# CITY OF ALBUQUERQUE

October 20, 2022

Re: **Jefferson Townhomes**  
**99999 Jefferson St. SE**  
**Traffic Circulation Layout**  
Engineer's Stamp 09-21-22 (K17-D099A)

Based upon the information provided in your submittal received 09-28-22, the above referenced plan cannot be approved for Building Permit until the following comments are addressed:

SITE PLAN

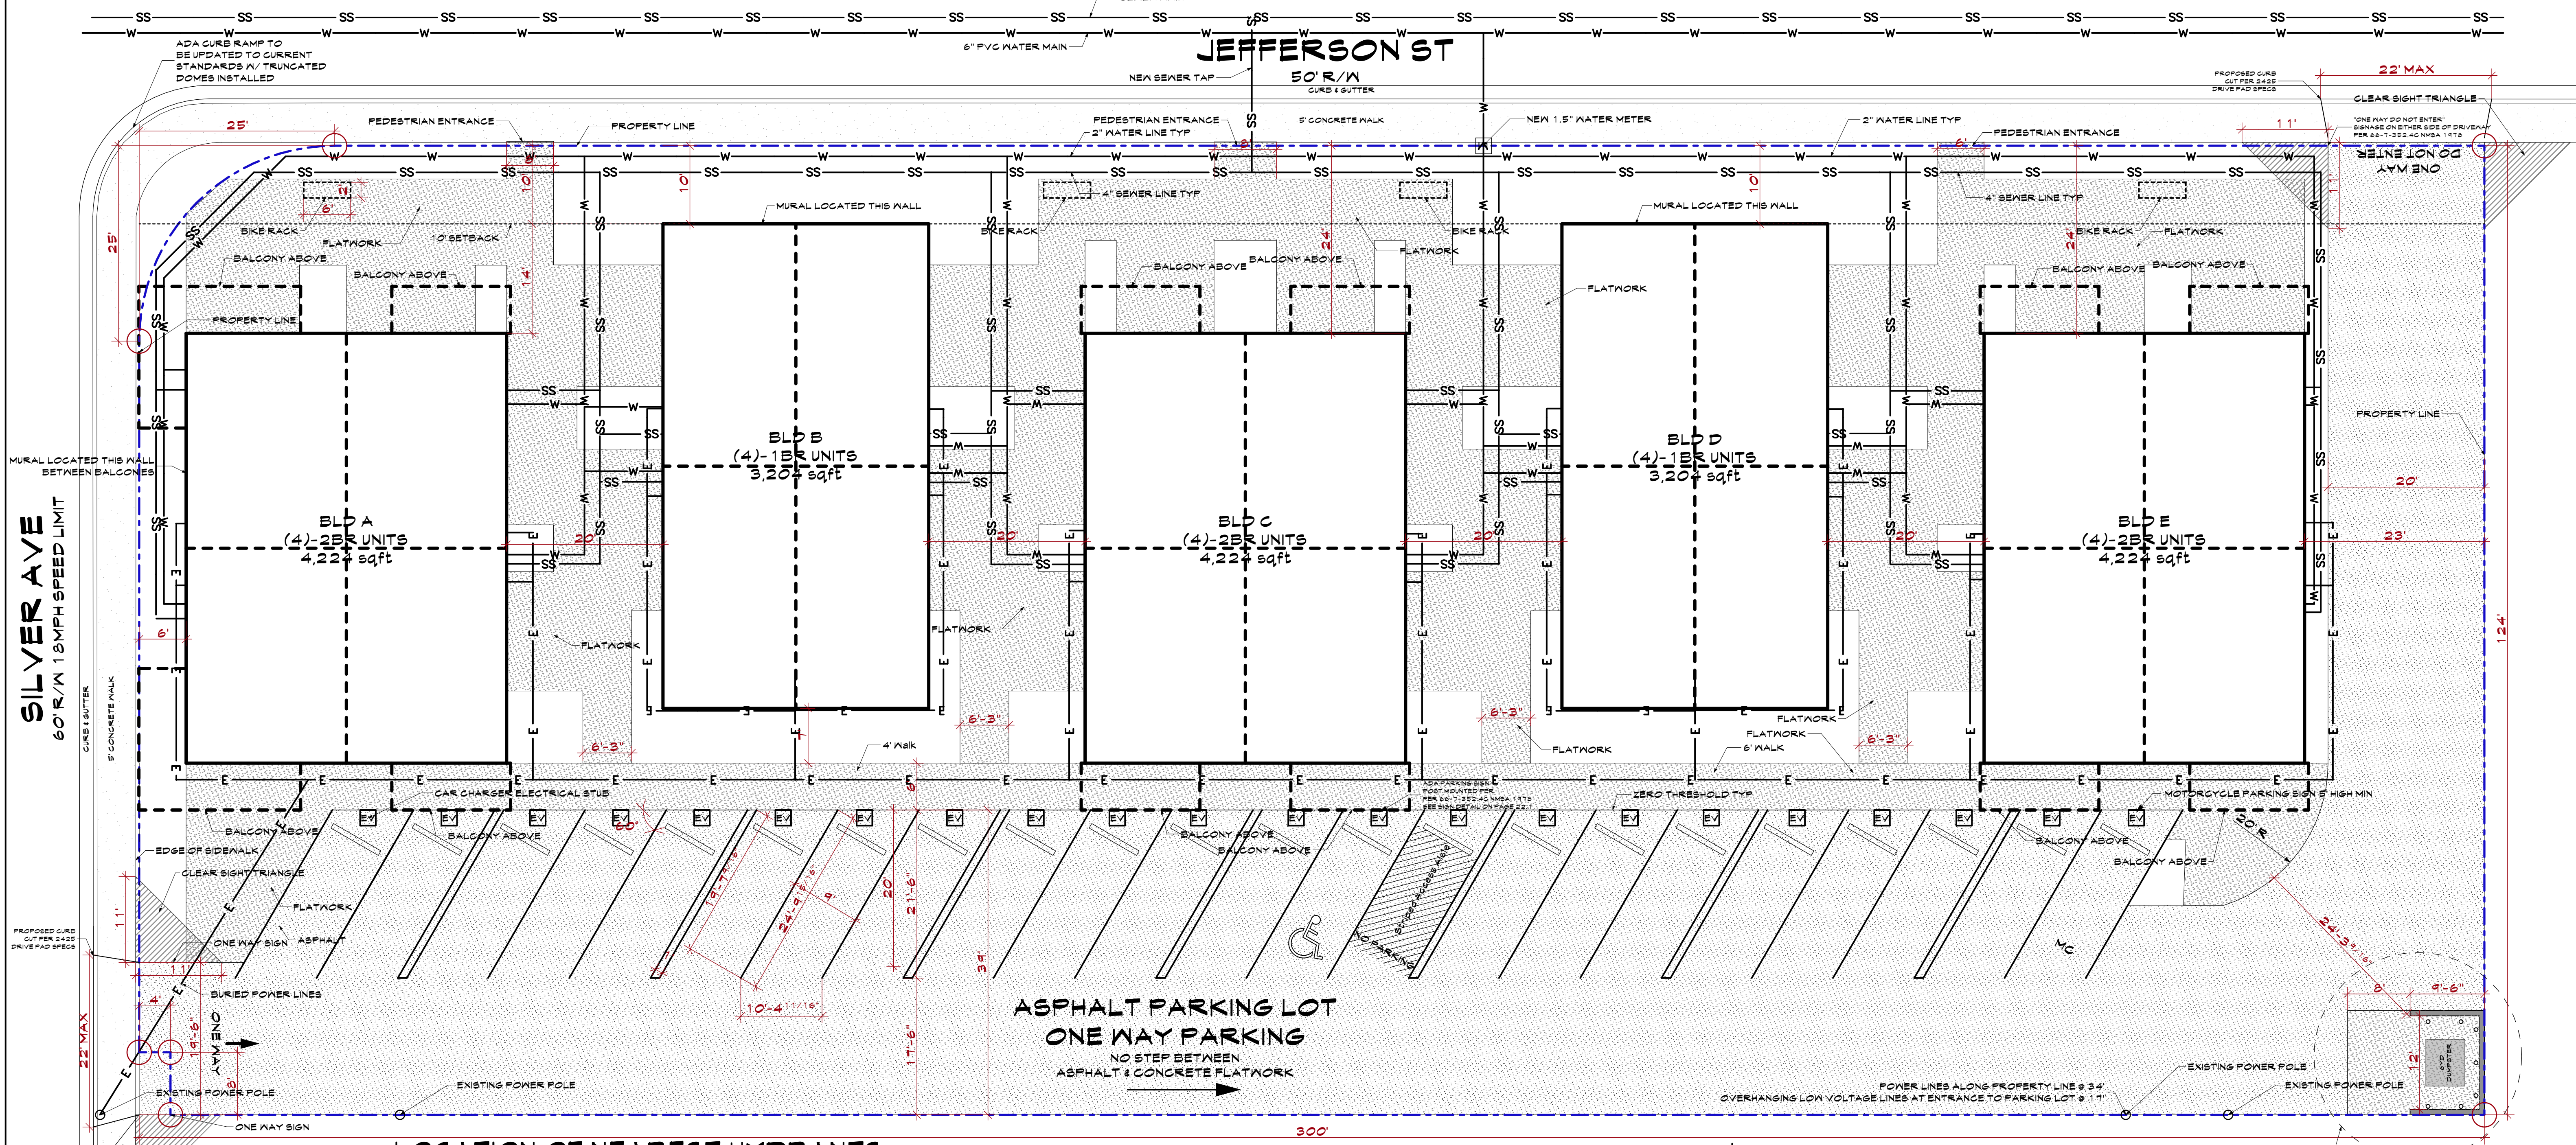
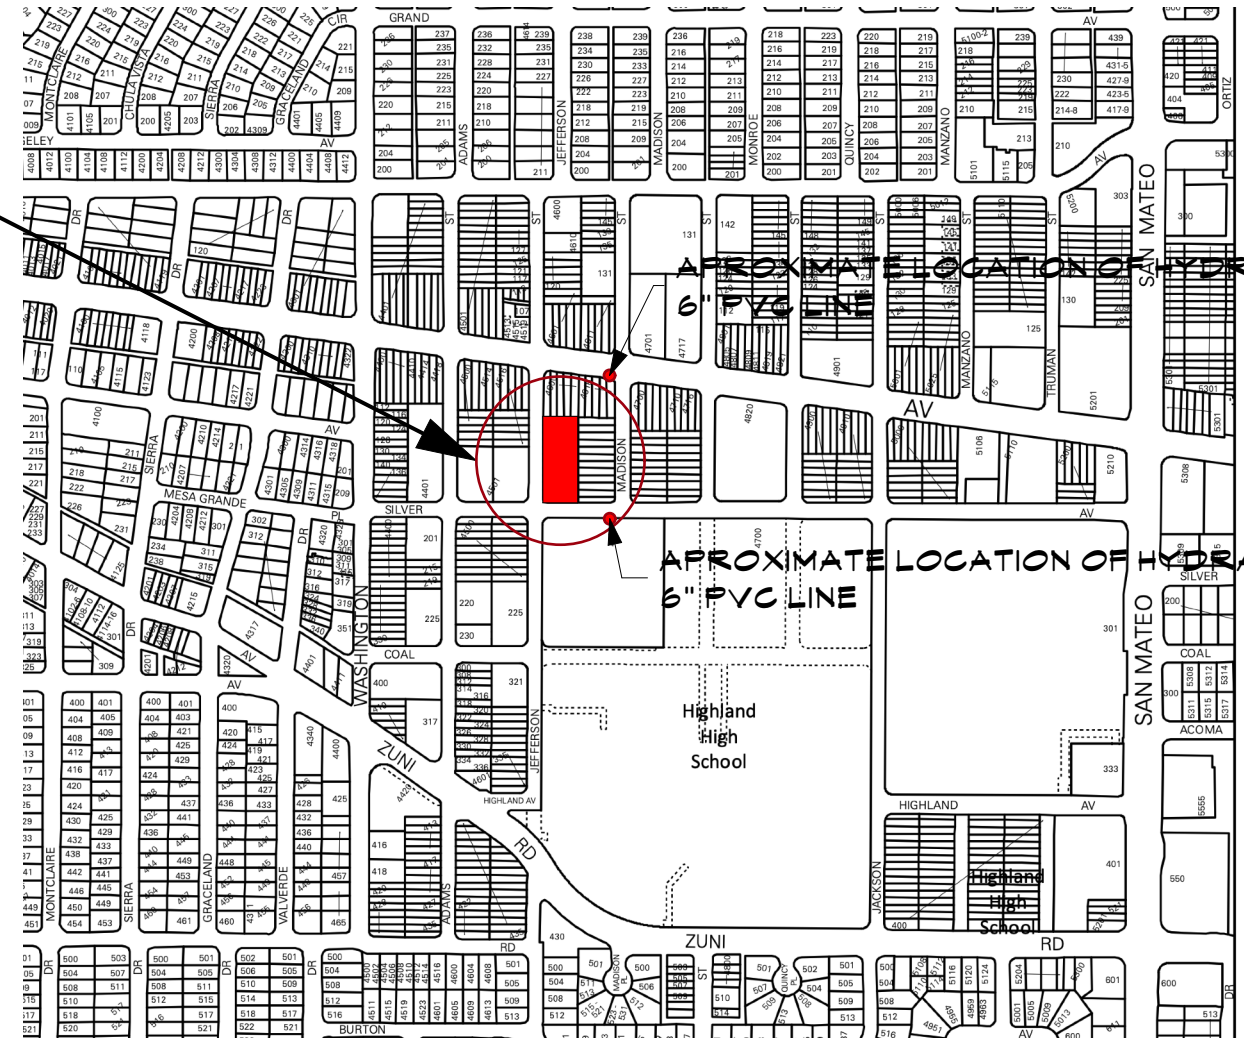
1. List the number of Motorcycle and Bicycle parking spaces required by the IDO.
2. ADA parking spaces need to be provided. See attached Accessible Parking requirements.

3. The width for the 60 degree angled parking should be min. 9.8 ft.
4. The ADA accessible parking sign must have the required language per 66-7-352.4C NMSA 1978 **"Violators Are Subject to a Fine and/or Towing."** Please call out detail and location of signs.

5. The ADA access aisles shall have the words **"NO PARKING"** in capital letters, each of which shall be at least one foot high and at least two inches wide, placed at the rear of the parking space so as to be close to where an adjacent vehicle's rear tire would be placed. (66-1-4.1.B NMSA 1978)

6. ADA curb ramp at the corner of Jefferson and Silver Ave. SE, must be updated to current standards and have truncated domes installed.
7. Motorcycle parking spaces shall be designated by its own conspicuously posted upright sign, either free-standing or wall mounted per the zoning code.

8. The pavement marking "MC" should be shown in the opposite direction for motorcycles entering the parking space.
9. All bicycle racks shall be designed according to the following guidelines:

- 13. Per the IDO, a 6 ft. wide ADA accessible pedestrian pathway is required from the public sidewalk to the building entrances. Please clearly show this pathway and provide details.

- 14. Per DPM, a 6 ft. wide ADA accessible pedestrian pathway is required from the ADA parking stall access aisles to the building entrances. Please clearly show this pathway and provide details.

- 15. ADA accessible pedestrian pathway should not be placed behind parking space or adjacent to a vehicular way. Vehicle and pedestrian/wheel chair conflicts should be avoided as much as possible.

- 16. Define ADA pathways by labeling of ramps, flush pavement, dimensioning of pathways, doorways, etc.
- 17. Refuse vehicle maneuvering shall be contained on-site. The refuse vehicle shall not back into the public right of way.; provide a copy of refuse approval.

- 18. Please provide a copy of Fire Marshal approval.
- 19. All one-way drives shall have "One Way" and "Do Not Enter" signage and pavement markings. Please show detail and location of posted signs and striping.

- 20. Show the clear sight triangle and add the following note to the plan: "Landscaping and signage will not interfere with clear sight requirements. Therefore, signs, walls, trees, and shrubbery between 3 and 8 feet tall (as measured from the gutter pan) will not be acceptable in the clear sight triangle.

- 21. Please specify the City Standard Drawing Number when applicable.
- 22. Unused curb cuts must be replaced with sidewalk and curb & gutter. A build note must be provided referring to the appropriate City Standard drawing.
